Application for Planning Permission

Development: Installation of 100 No solar panels. This application may affect the Shripney Conservation Area and is in CIL Zone 3 (Zero Rated) as other development.
Location: Shripney Manor Shripney Lane Bersted PO22 9NU

I regret that I am unable to accept your documents as a valid application until the following item(s) have been received or resolved :-

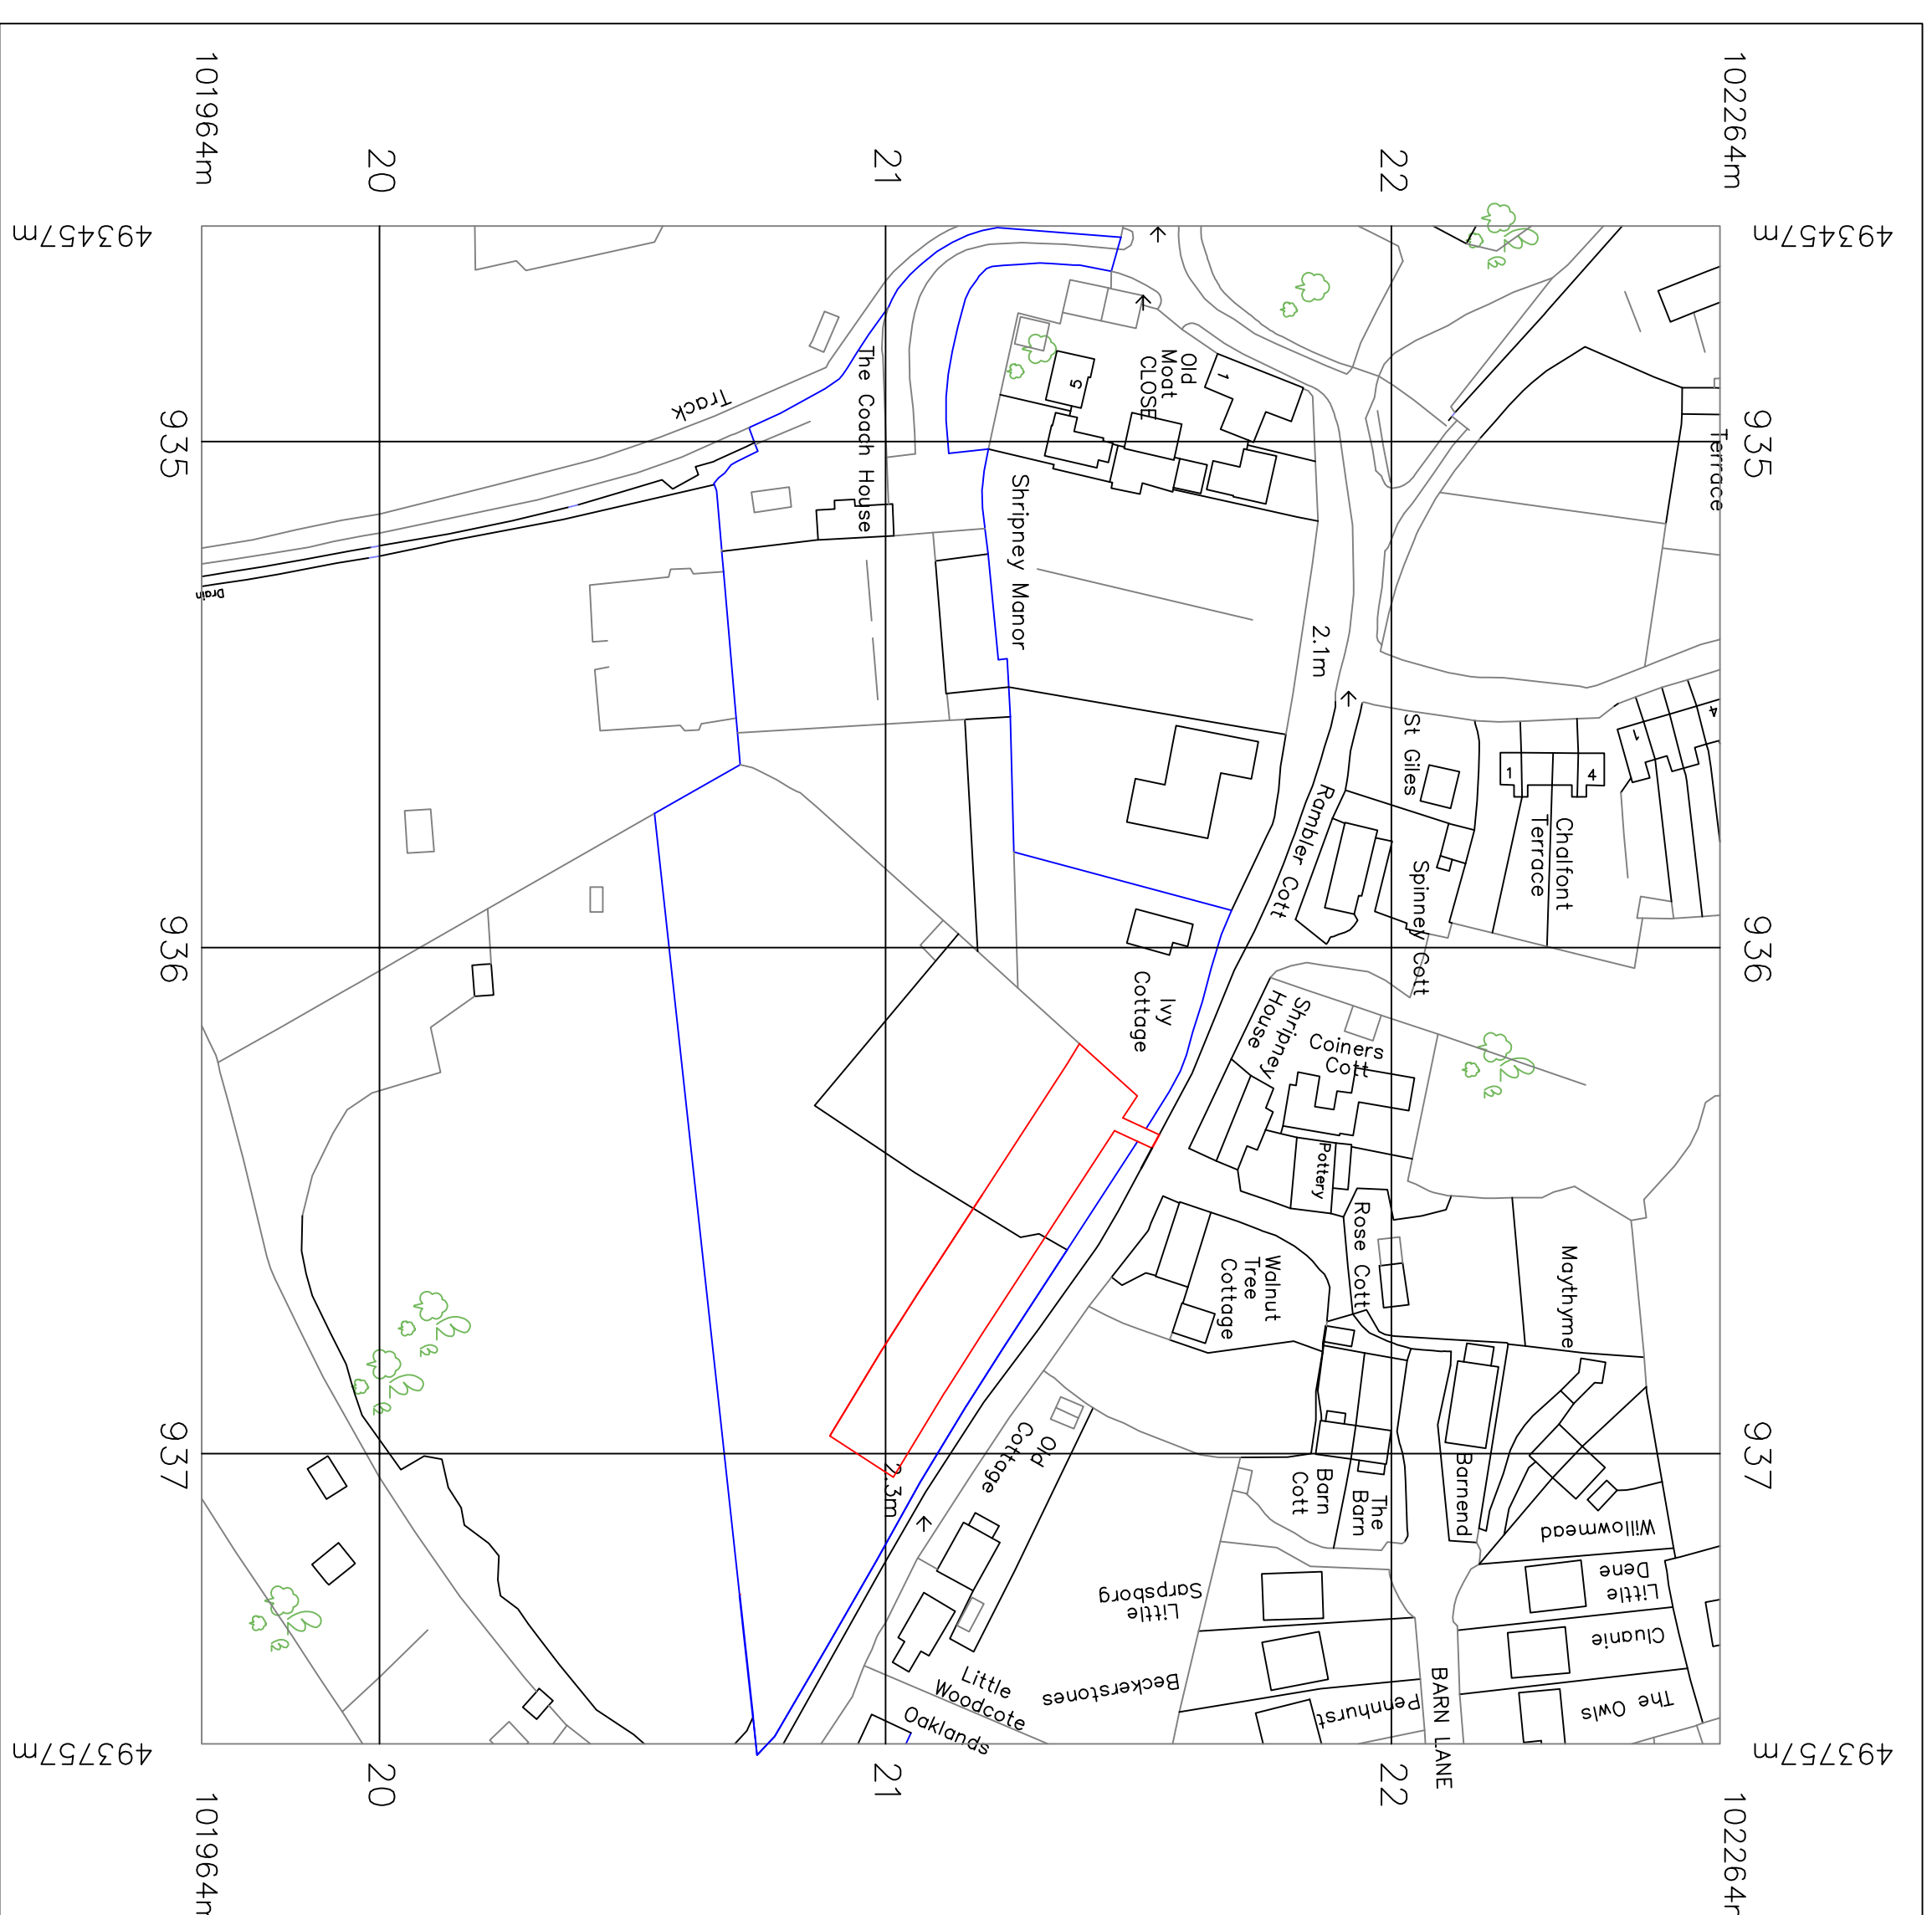
Location Plan

Please show access, to the main road within the red edge.
